Rezoning Transportation Analysis

Petition Number: 2020-054

General Location Identifier: Tax ID 14525501

Revision Log:	Date	Description
	05-18-20	First Review
	06-24-2020	Second Review (KP)

RZ-2

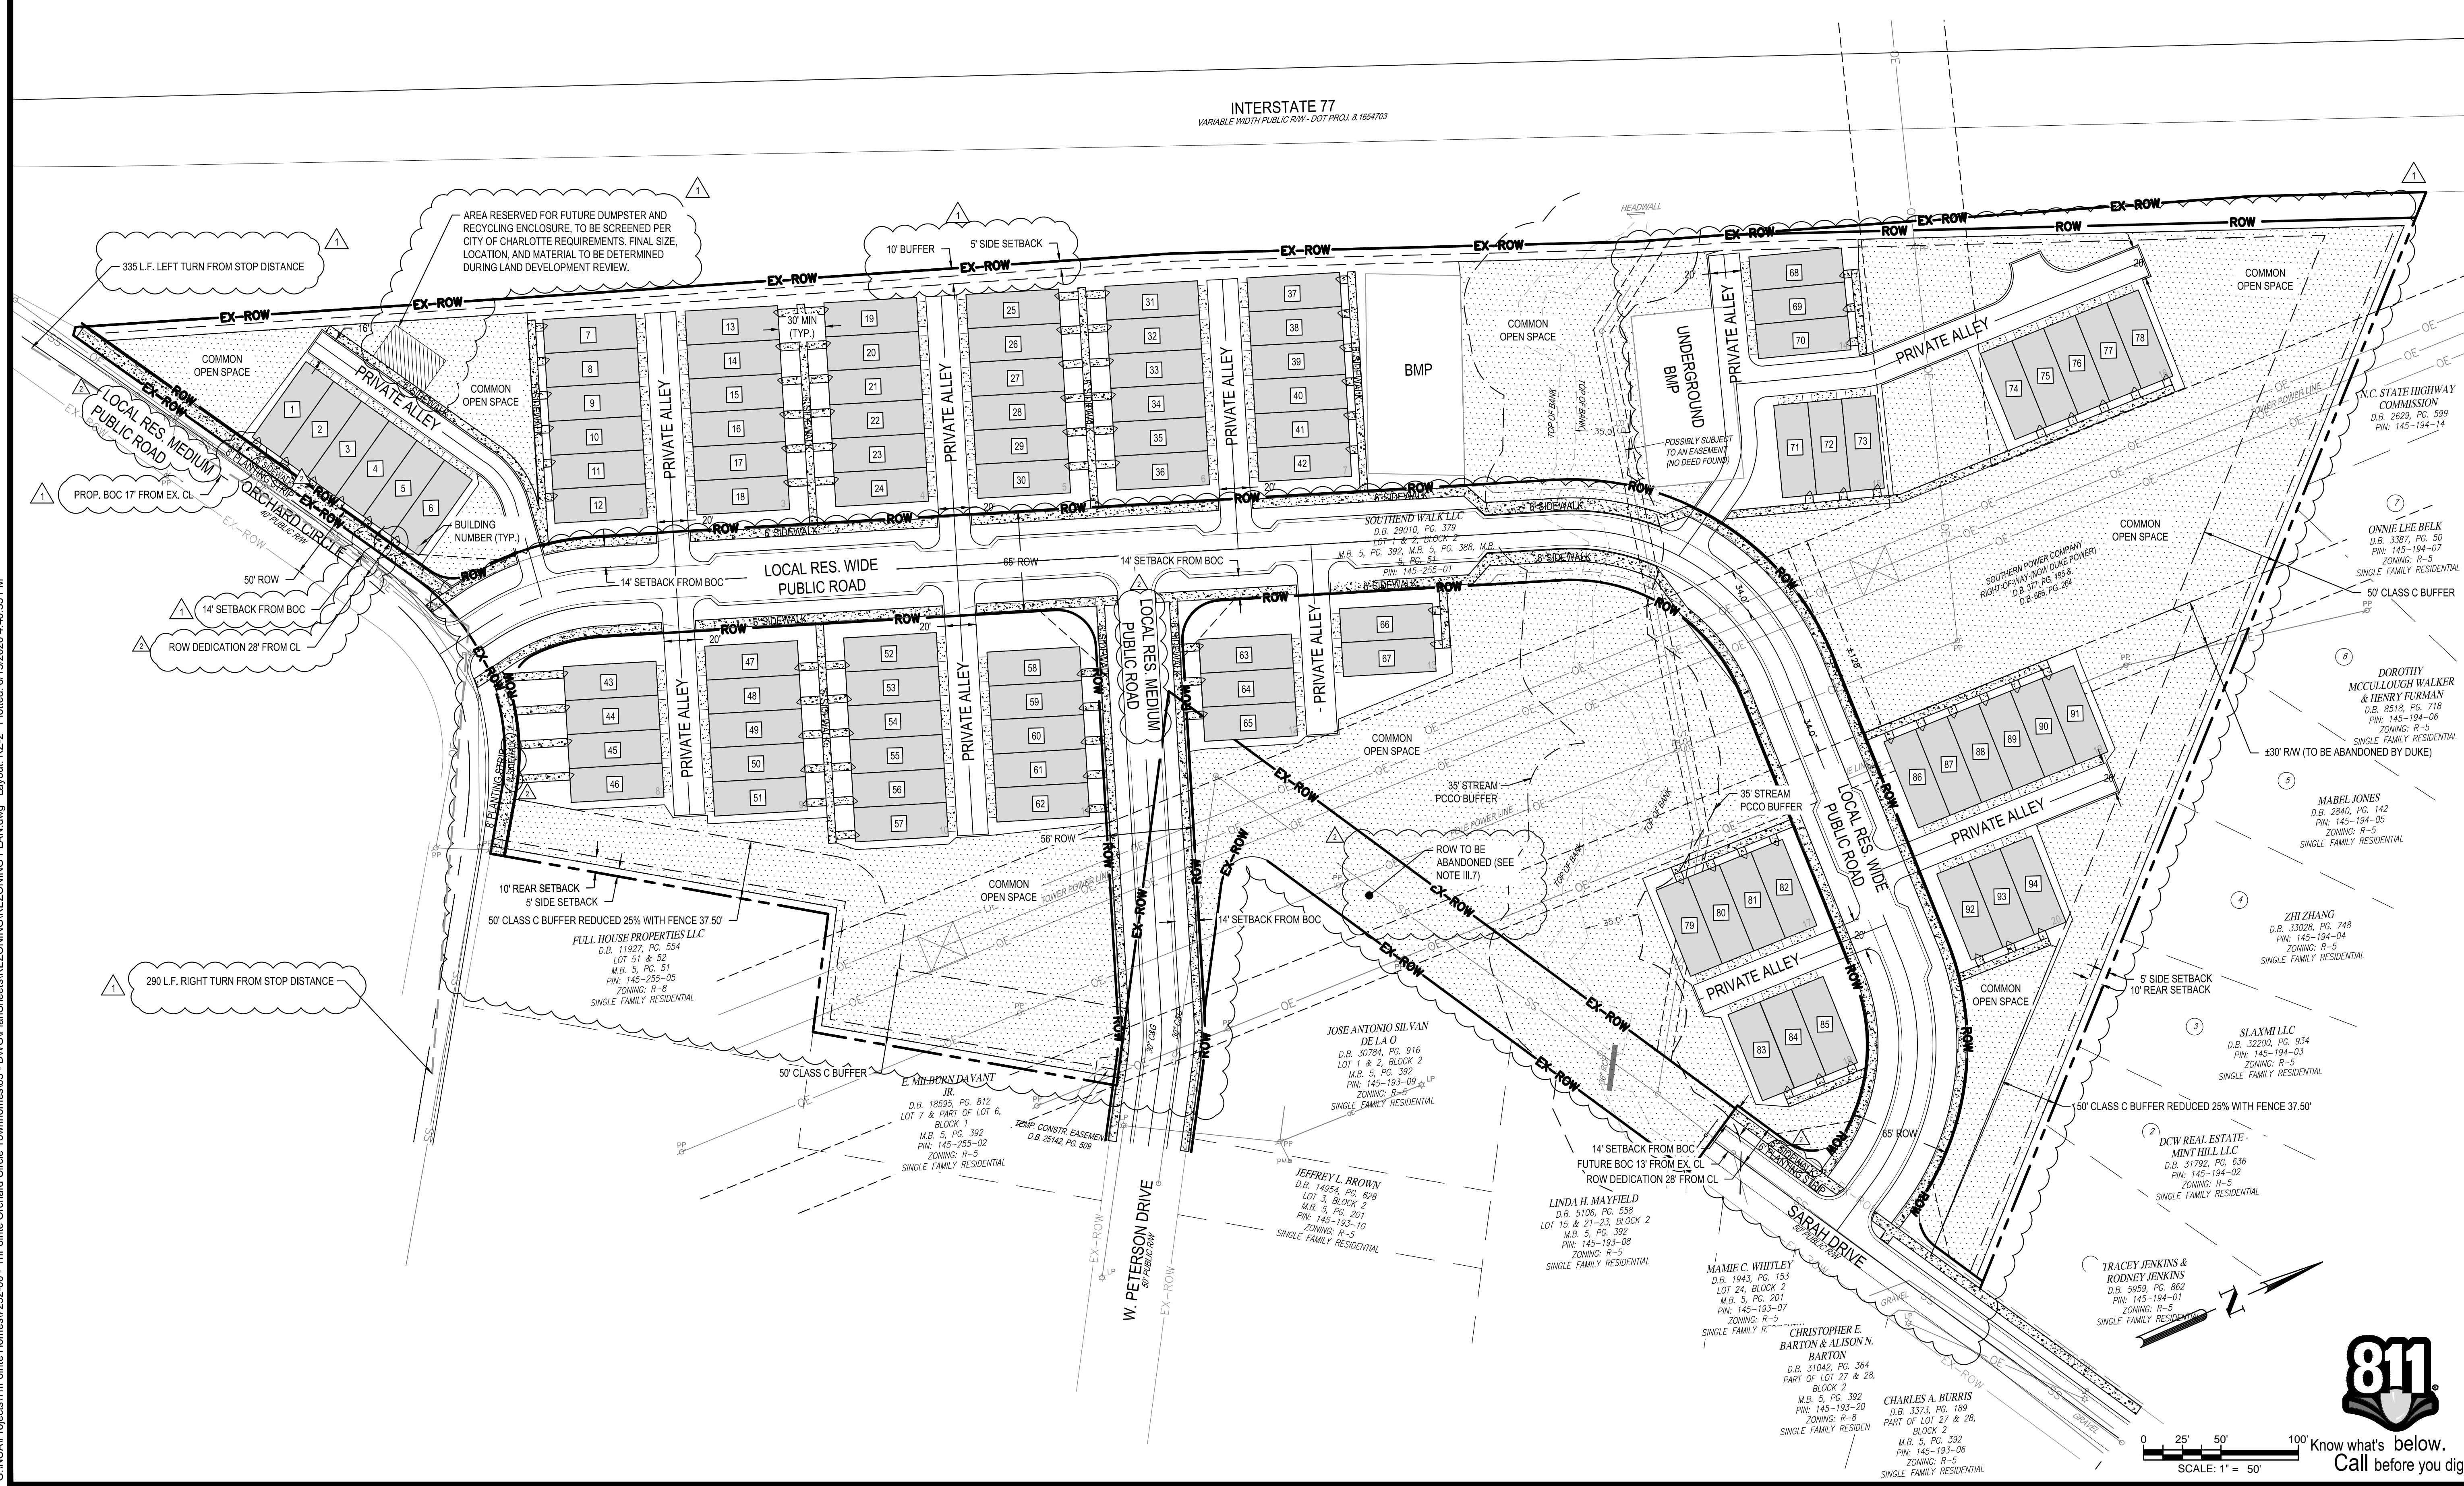
The site is located on I-77 (state-maintained) and existing local roads (city-maintained). The petitioner should commit to installing 6' sidewalks and an 8' planting strip throughout the property and the property's frontage in accordance with city standards. The petitioner should commit to additional connectivity, both vehicular and pedestrian, at W. Peterson Drive, Sarah Drive, and Orchard Circle.

The site plan should show the curb and gutter **labeled and dimensioned** from the centerline for each road.
